27 July 2015

Department of Planning and Environment
23-33 Bridge Street
Sydney NSW 2000

**Letter of objection to Staged Concept Proposal SSD 6454– SCEGGS Redlands 272 Military Road, Cremorne (Proposal)
Unit 1/19 Waters Street Neutral Bay NSW (Property)**

STAGE COMPLETE SECTIONS

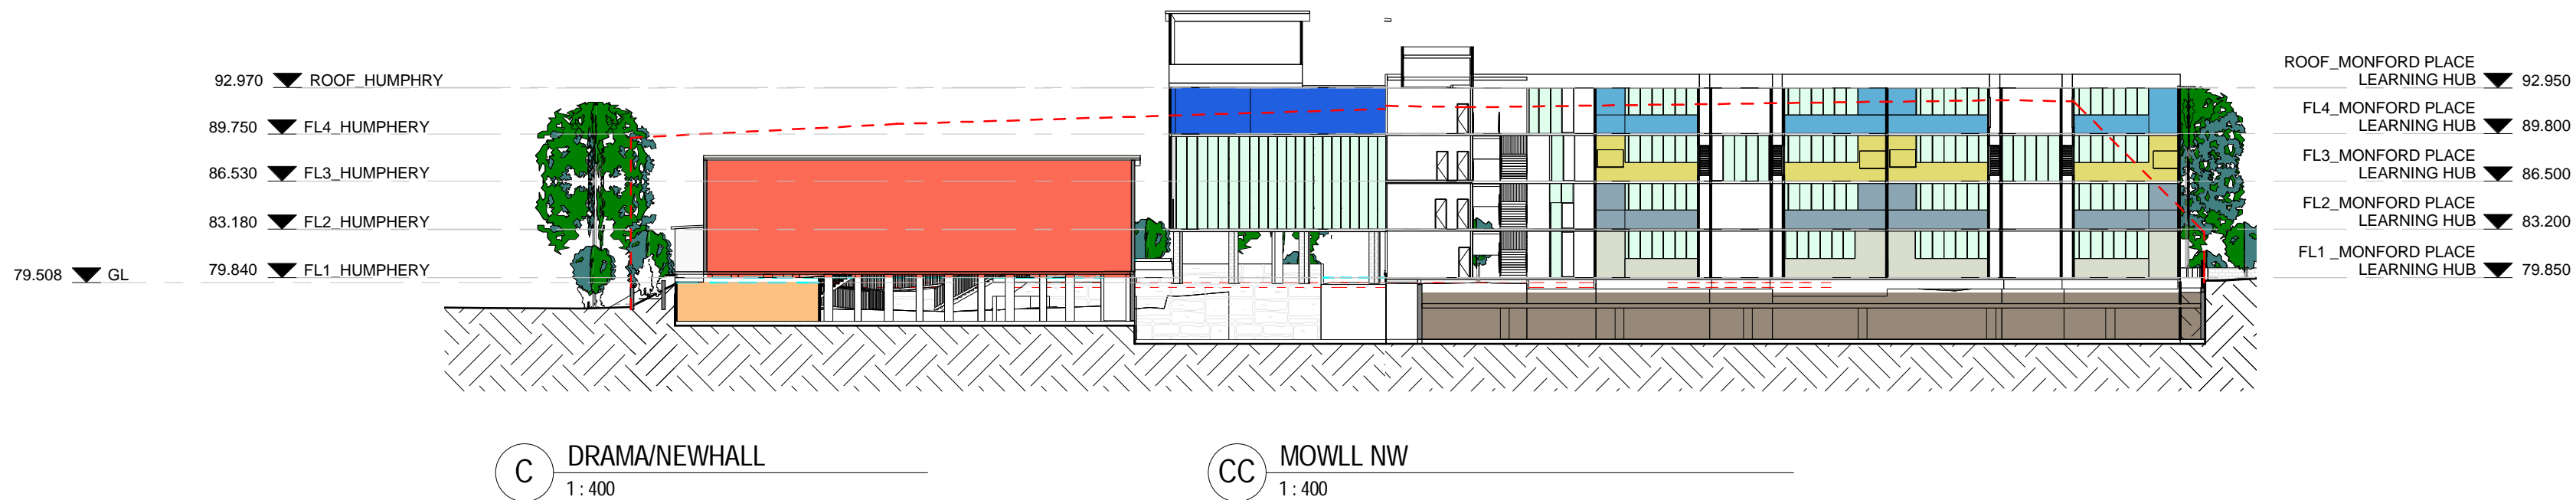
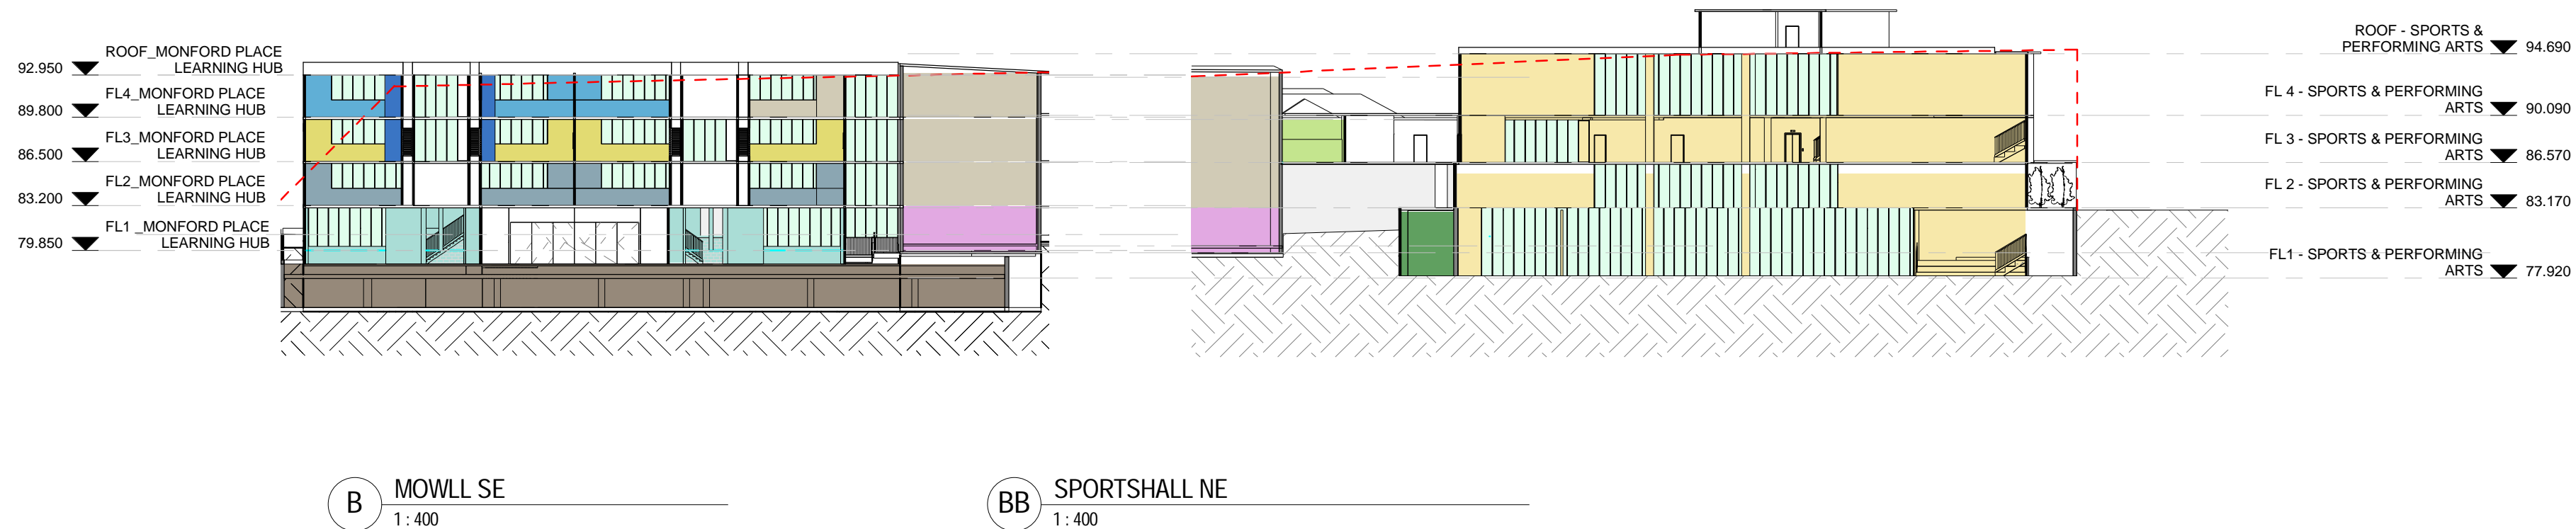
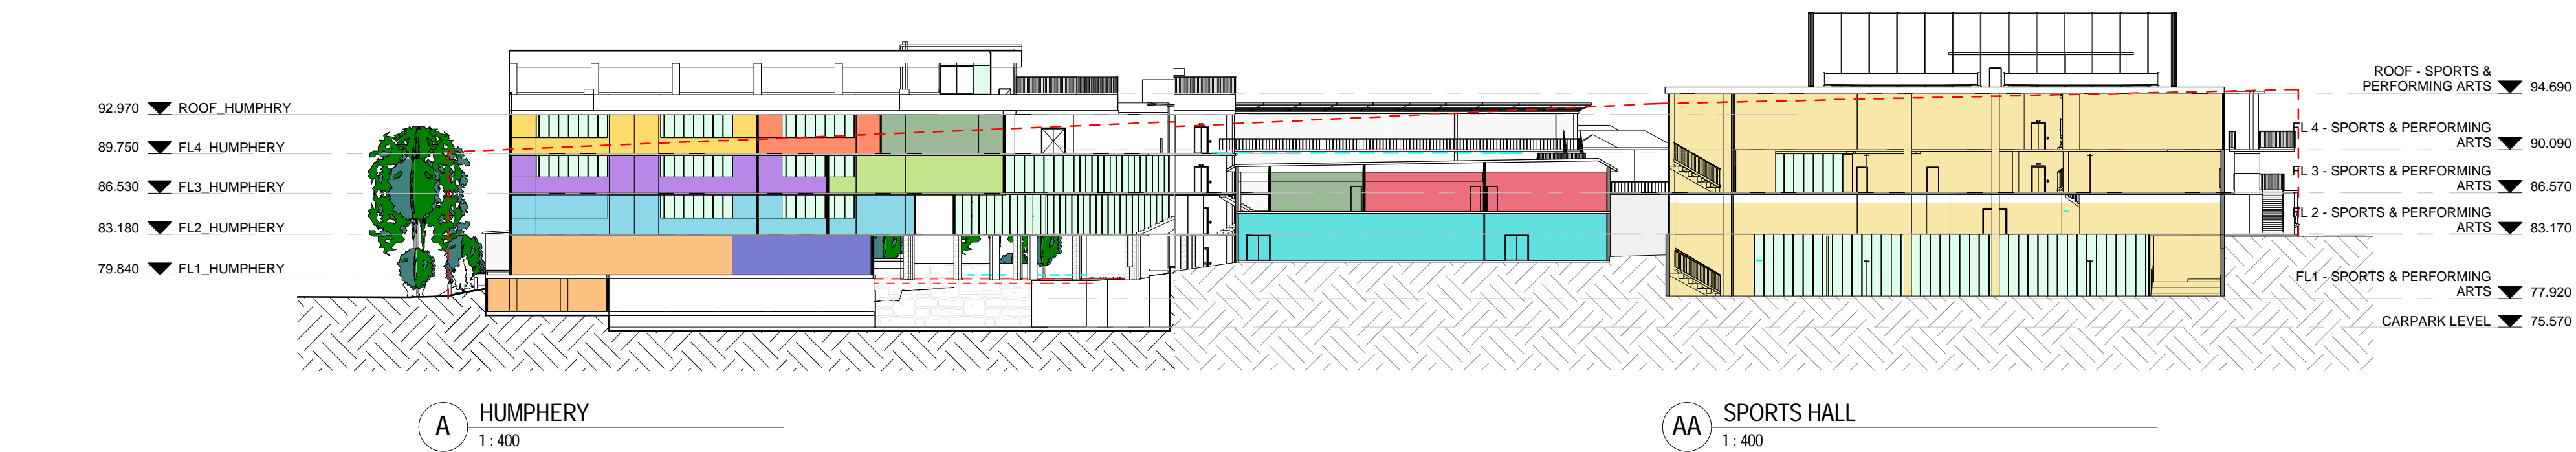
The building is designed as one large 'box-type' mass directly at the rear of our client's townhouse home, separated only by a driveway. The height and bulk of the proposed building, combined with the totally inadequate setback from our client's northern boundary would, if approved, have significant impacts on our client's property.

4. The loss of solar access that would be caused by the bulk and 4 storey building is unjustifiable on any merit assessment. Our client's living room and courtyard are located on the ground floor of the property, and the height of the building, being 4 storeys, will completely overshadow our client's primary living areas. It is also contrary to the Land and Environment Court's planning principle in *The Benevolent Society v Waverley Council* [2010] NSWLEC 1082, which relevantly held that:
